Planning Inspectorate

Our ref: OR-0002198/01

Date: 04 June 2026

Application by Photovolt Development Partners (“the Applicant”) for an Order granting Development Consent for the proposed Botley West Solar Farm (“the Proposed Development”)

**Illustrative Masterplan
Figure 5.5G: Cable Corridor Option G**

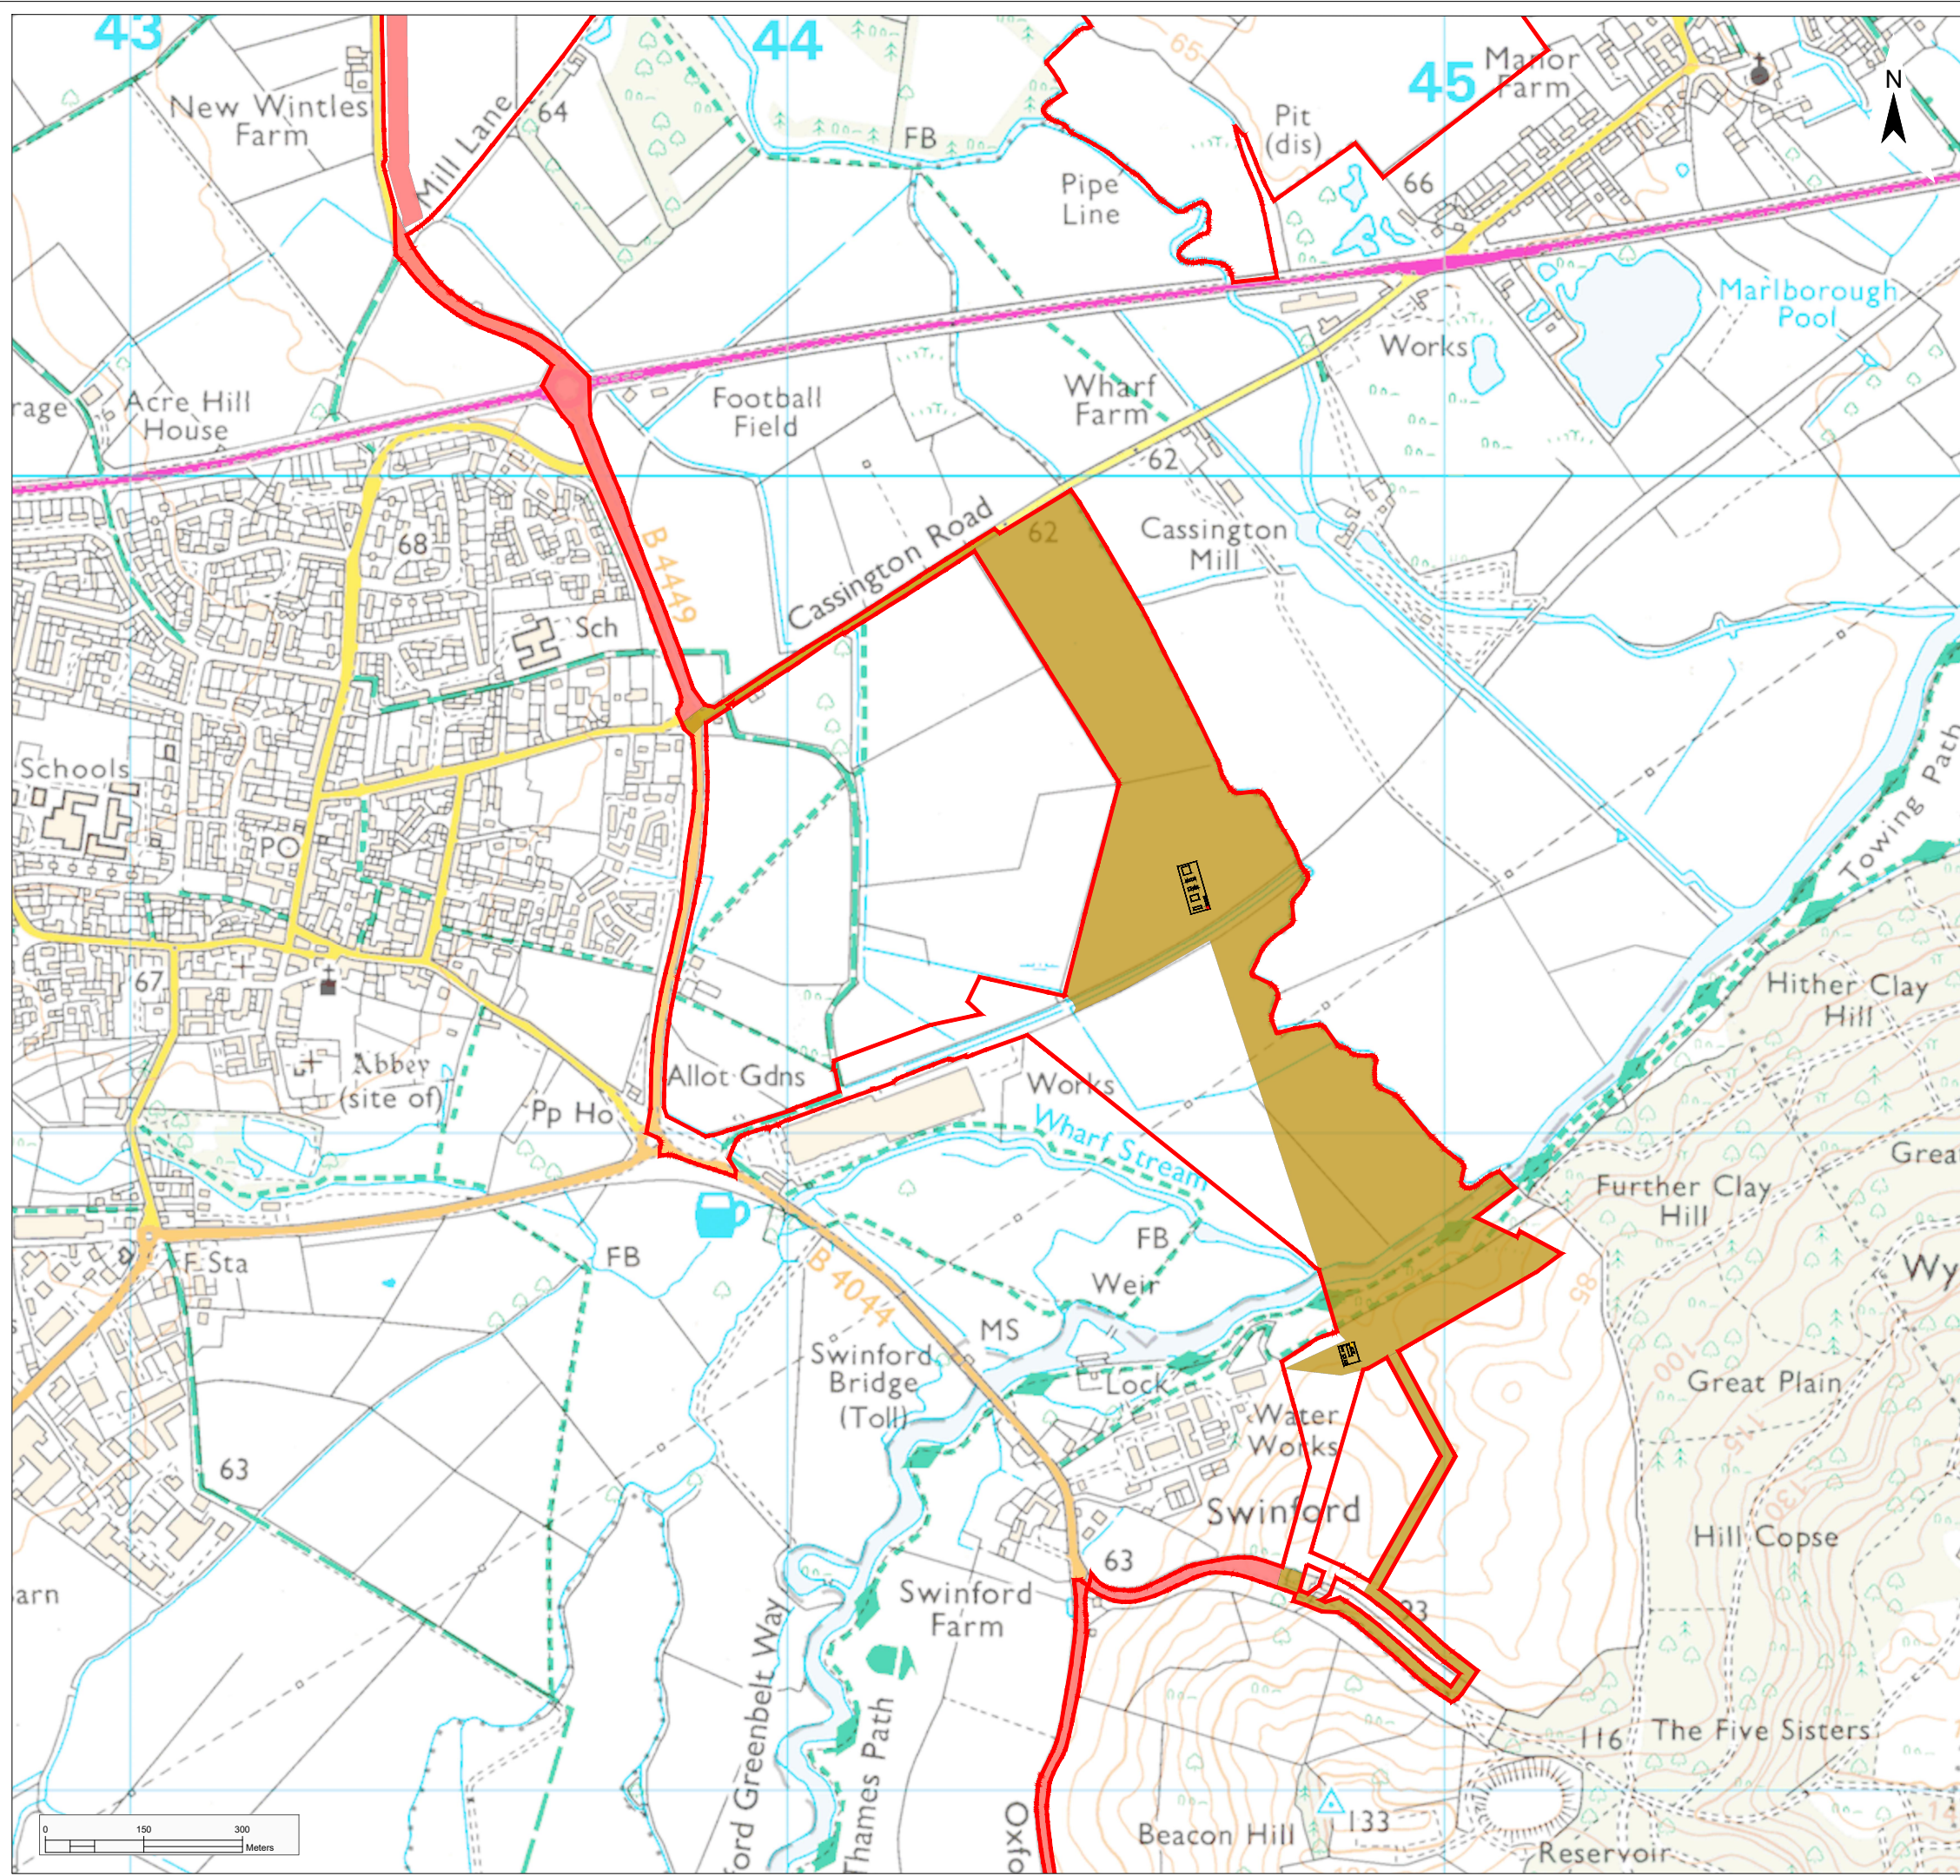
We have reviewed the Hydrology and Flood Risk Technical Note – Swinford HDD Crossings (REP6-054). The applicant has adequately justified why they are unable to move the Horizontal Directional Drilling (HDD) entrance pit at Swinford outside of Flood Zone 3b. We consider this justification is reasonable in the context of wider site-specific constraints.

Considering the proposed mitigation measures, inclusive of the additional mitigation measures (section 1.4.4), if the applicant complies with these, we consider that the approach is reasonable.
